Change of use of store to single dwelling with porch extension & alterations. This application is a departure from the development plan

Walberton House The Street Walberton

Thank you for your internet representation made on 1st April 2014 which has been recorded as '**an objection**' with the comments as follows:

PROPOSED GROUND FLOOR PLAN 1:50

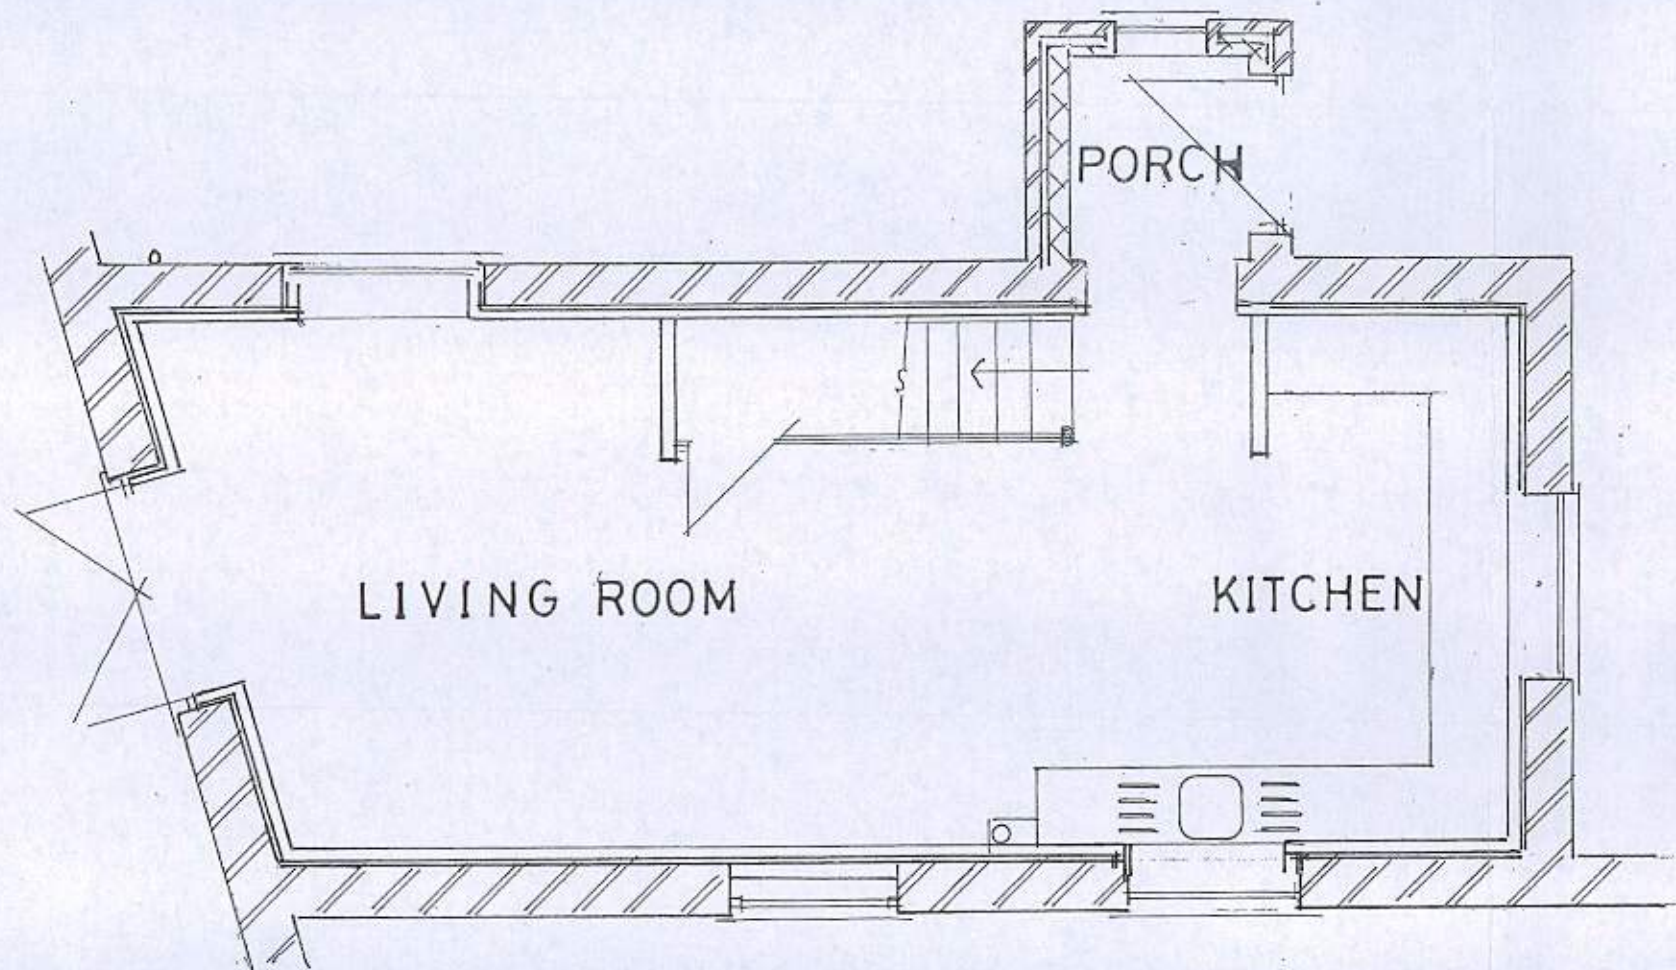
*The Walberton Park Management Company are supportive of the Application in principle but the location of the new entrance on the west elevation is illogical when the two parking spaces are located on the east side of the boundary wall. It will result in the cars being parked on the drive to Walberton Park.*
